March 14, 2008

RE: 41 Church Road, Cliff Island – 109B F010 – IR-1 – permit # 08-0230

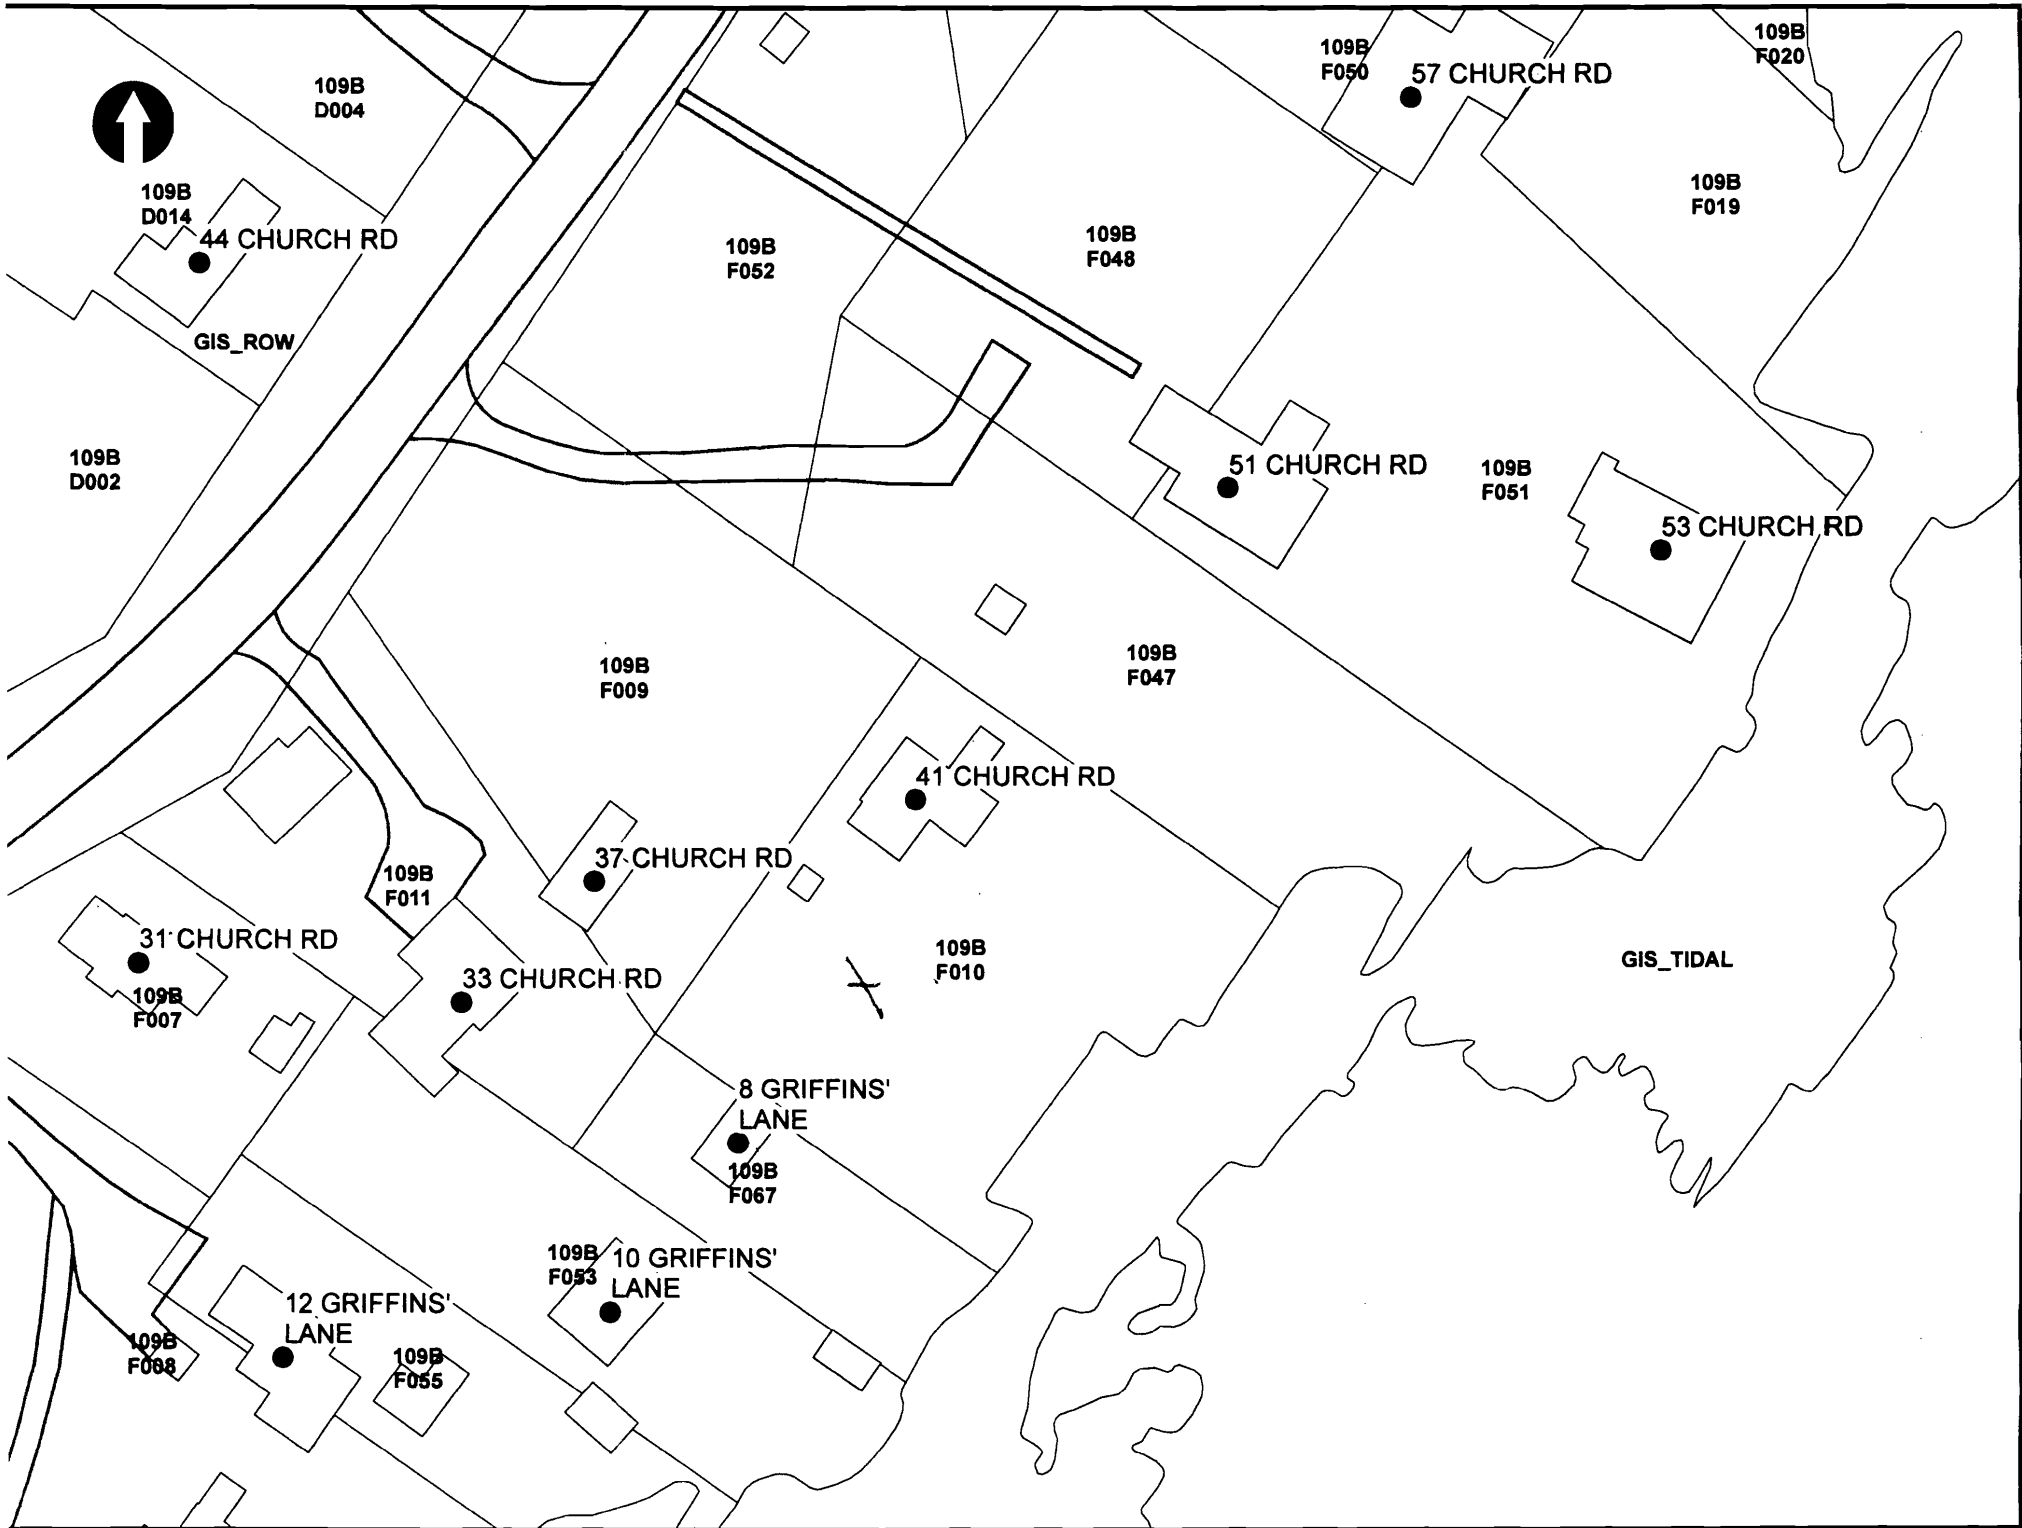
This letter is a follow up to our telephone conversation from yesterday. As we discussed, there are two issues with the permit application for the proposed porch extension and new entry porch at your property at 41 Church Road, Cliff Island. The first issue is that your property falls within the shore land zone. Section 14-449(a)(1) of the ordinance states that “all principal and accessory structures shall be set back at least seventy-five (75) feet” from the high waterline. The ordinance goes on to give an allowance for limited expansion in buildings that existed as of June 15, 1992. Since you are located in the shore land zone, for you to do any expansion to your building we need a certified site plan completed by a professional surveyor or engineer that locates the seventy-five foot setback line from the highest spring tide in relation to your existing building and the proposed expansion. We cannot process your permit without this stamped site plan.

The second issue with your permit application is that your proposed porch expansion does not meet the rear setback requirement. Your property is located in the IR-1 residential zone. Section 14-145.5(c)(2) gives the rear yard setback as thirty feet. Your plot plan shows that there is only nine (9) feet to the rear property line. Since the proposed expansion does not meet the rear setback, we cannot allow you to expand the porch.
